Our Ref: P/37/11/

Mrs D Johnson
(01903) 737500 Ext 37454
3rd May 2011

**Removal of existing garage (at front of property) and re-sitting of garage at rear of property
64 St Thomas Drive Pagham**

Title : Existing North & West Elevations
Address : 64 St Thomas Drive, Pagham.
Date : 05,04,11
Scale : 1:100
Dng.No : EE02

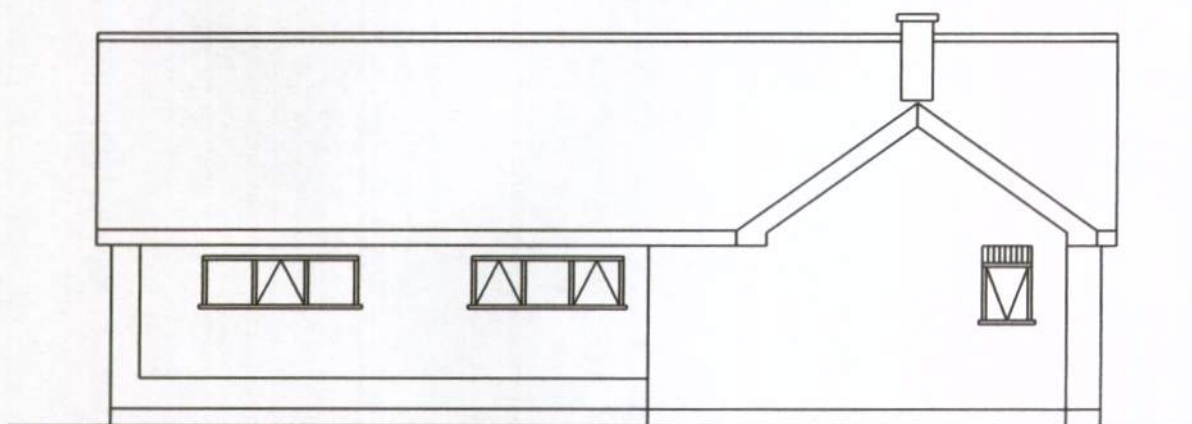
The existing and proposed West and South floor plans do not accord with the existing and proposed West and South elevations. Please amend accordingly.

Title : Proposed North & West Elevations
 Address : 64 St Thomas Drive, Pagham.
 Date : 05,04,11
 Scale : 1:100
 Dwg.No : PE05

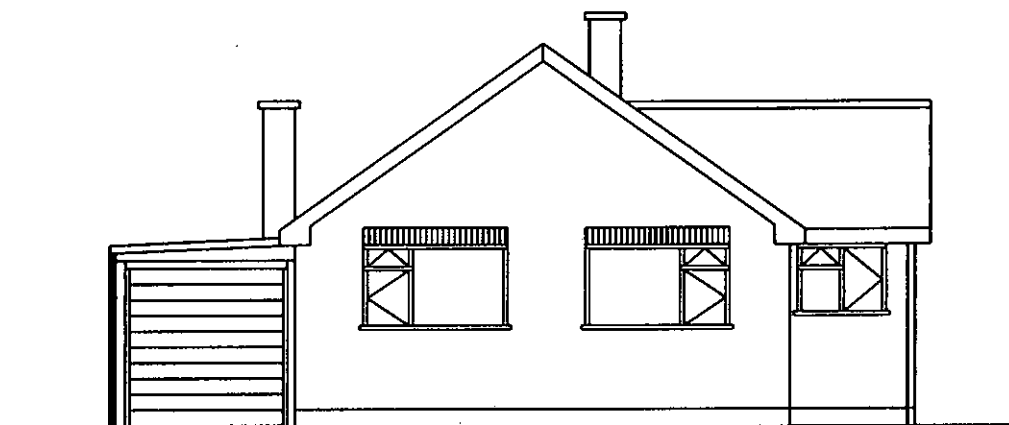
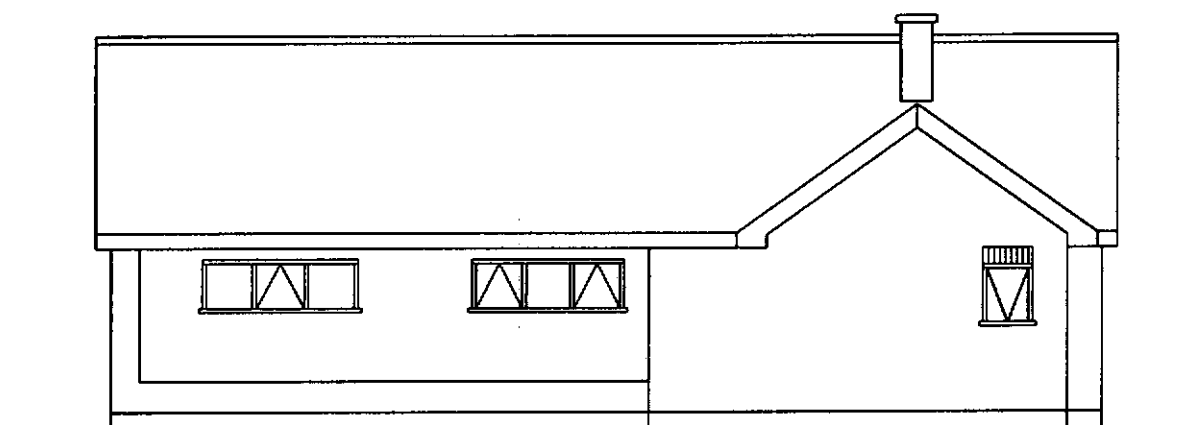
The proposed North floor plan does not accord with the proposed North elevation. Please amend accordingly.

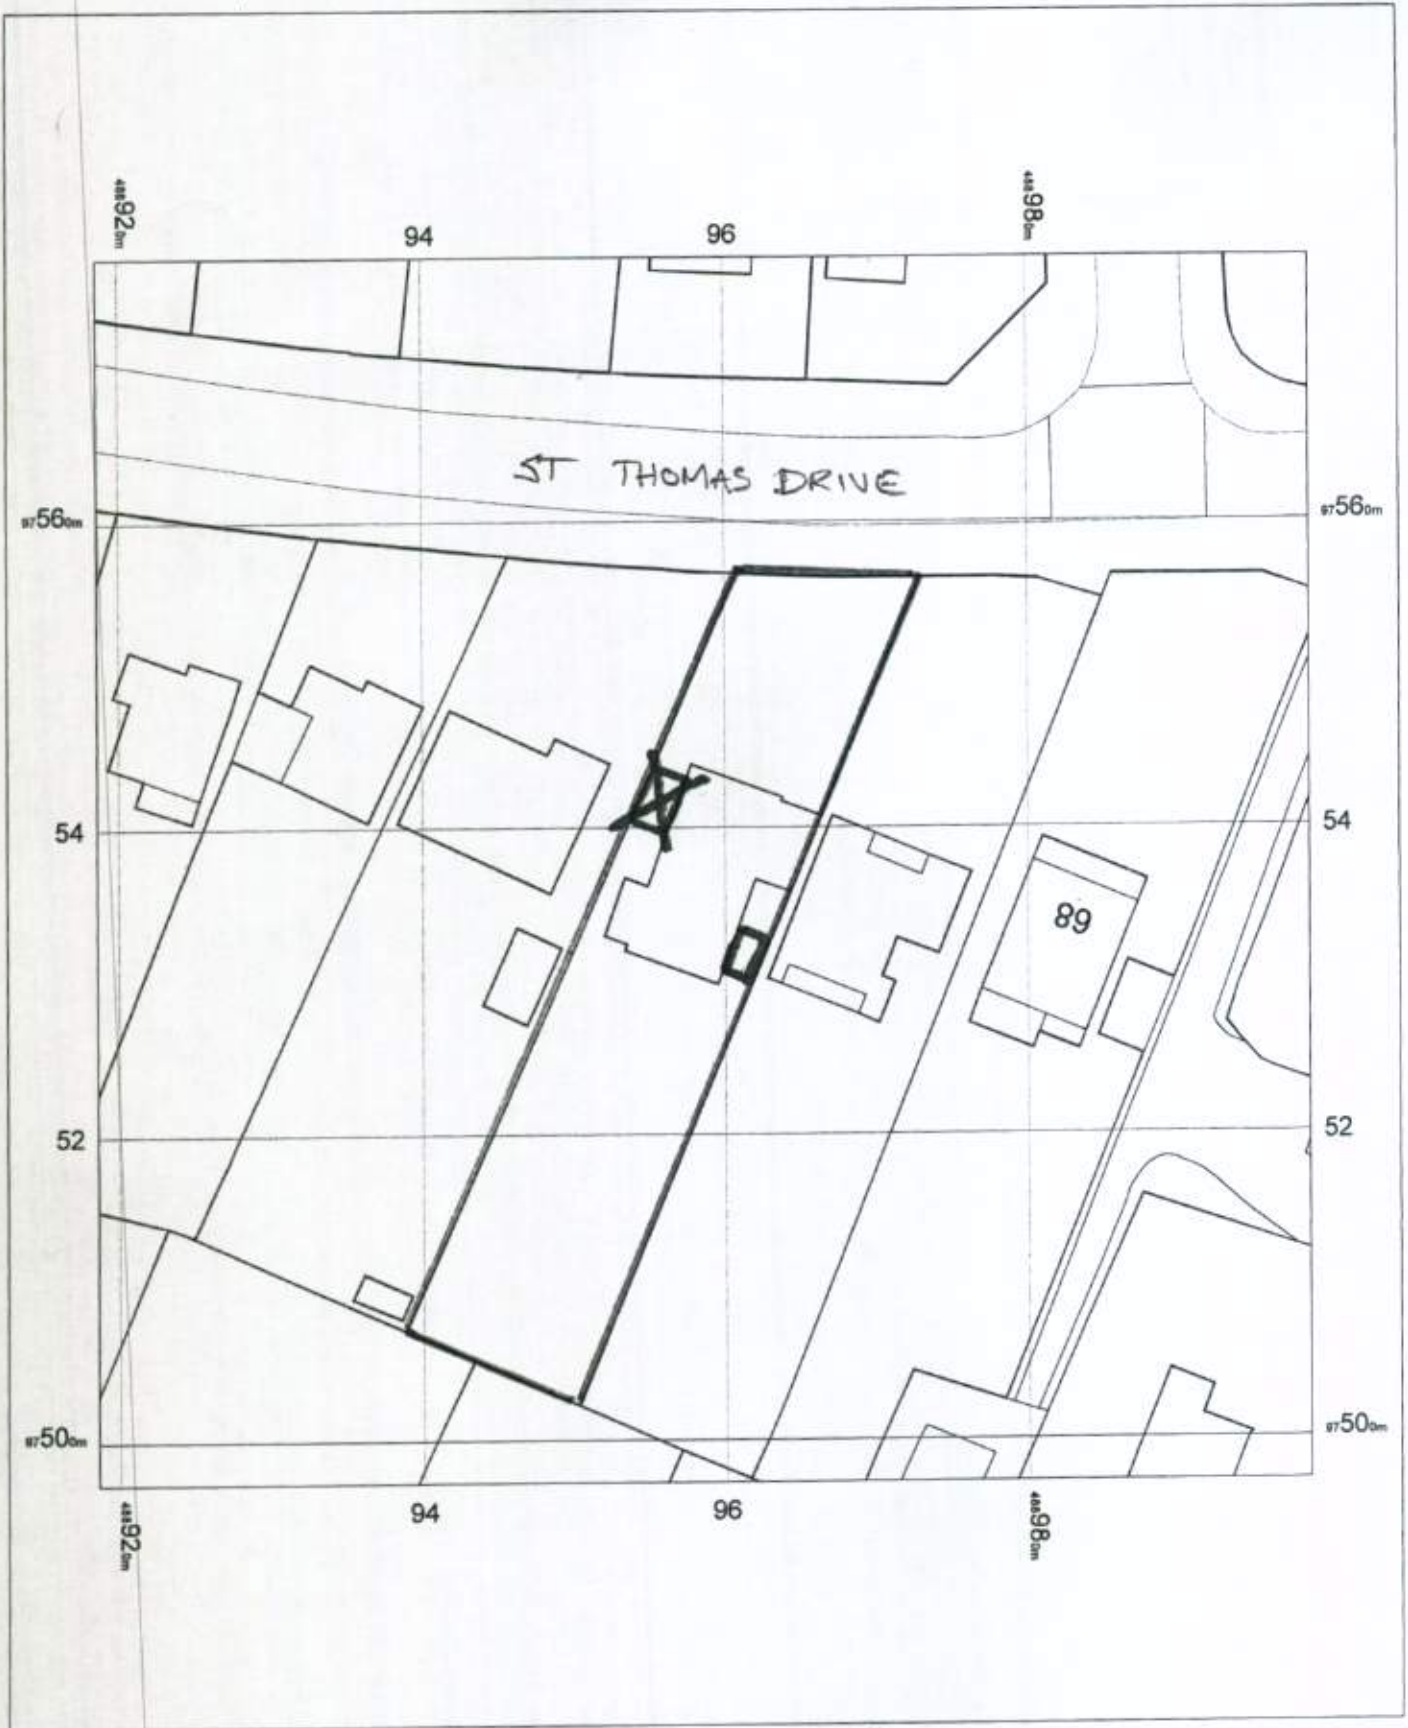
I require 1 electronic or 3 paper copies of a block/site plan in accordance with the guidance notes available on our website detailed below (click on National List). Please highlight the proposed works.

Title : Proposed Floor Plan
Address : 64 St Thomas Drive, Pagham.
Date : 05,04,11
Scale : 1:100
Dng.No : PFP04

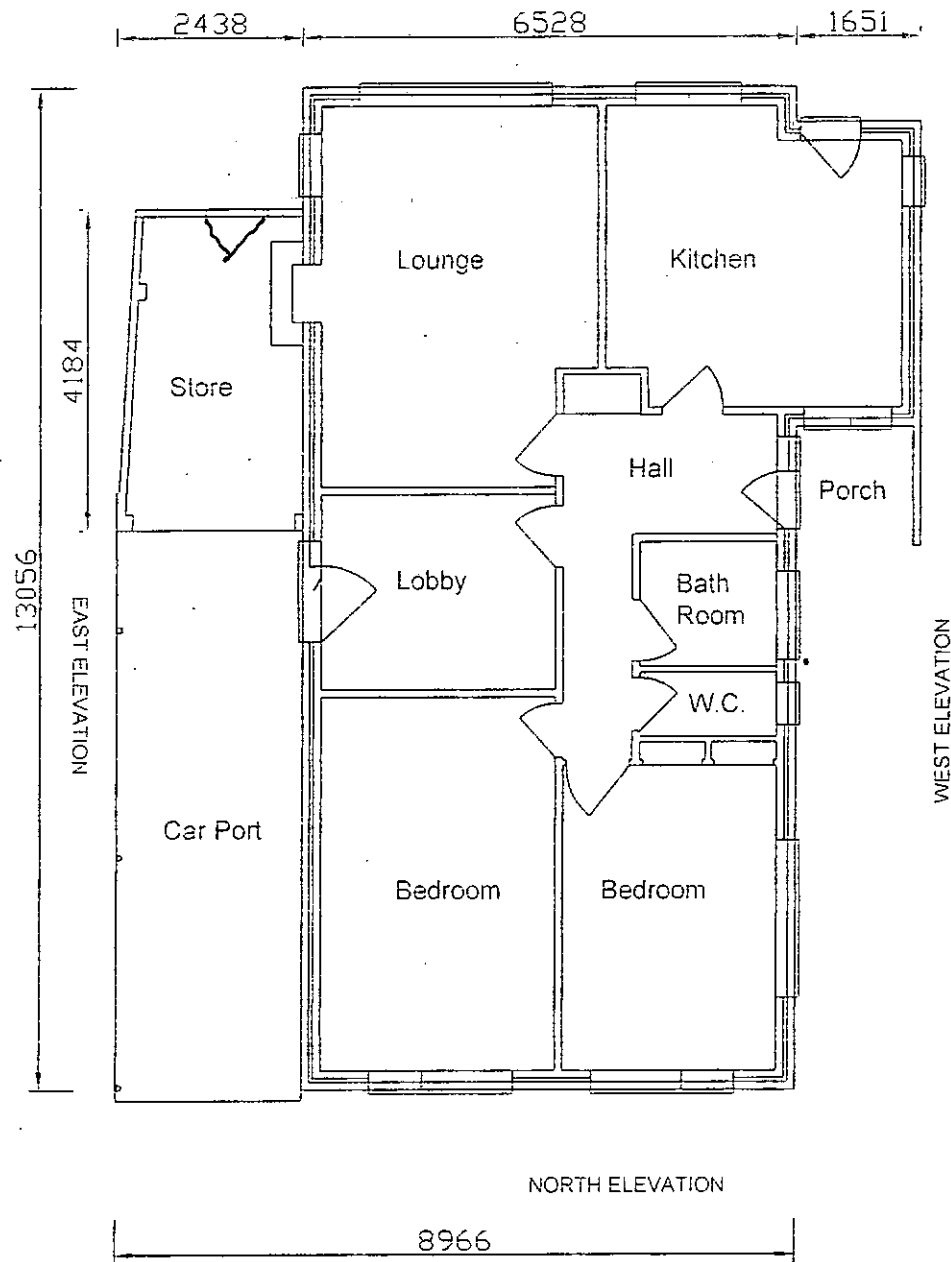
Please provide proposed floor plans and proposed elevations for the new garage that is being sited at the rear of the property.
